JACKSON Office Warehouse
Storage Buildings SDP
8140 SANDY COURT
COLORADO SPRINGS, COLORADO 80915

Project No. LGS17-1523

Storage Buildings SDP  
 Final Landscape Plan

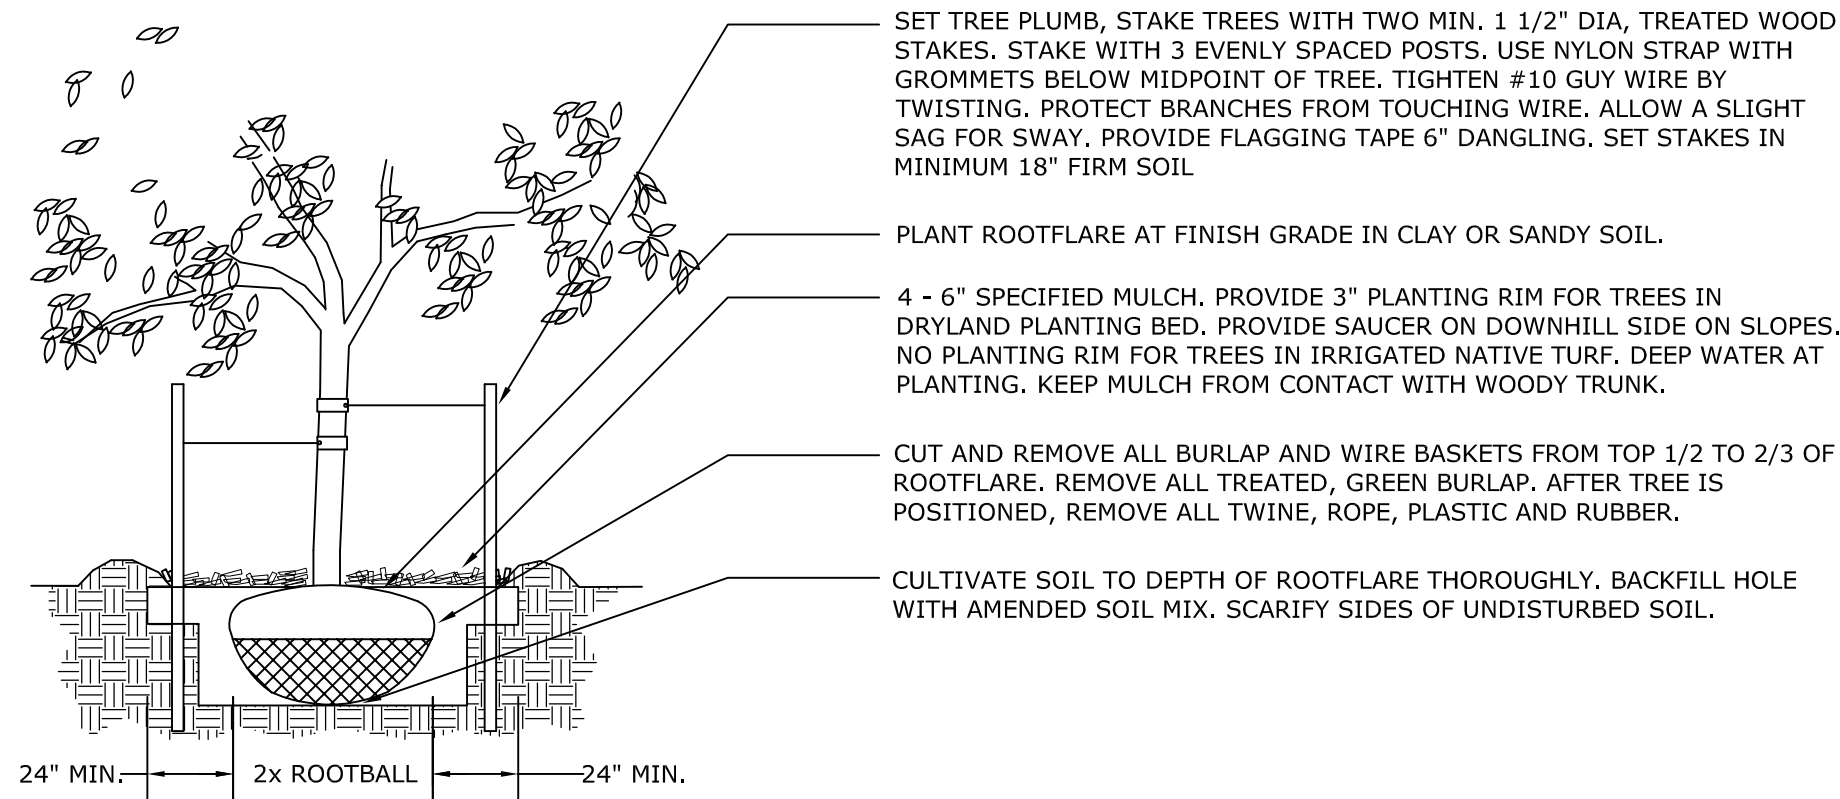
Needs Screening, minimum 3 feet.
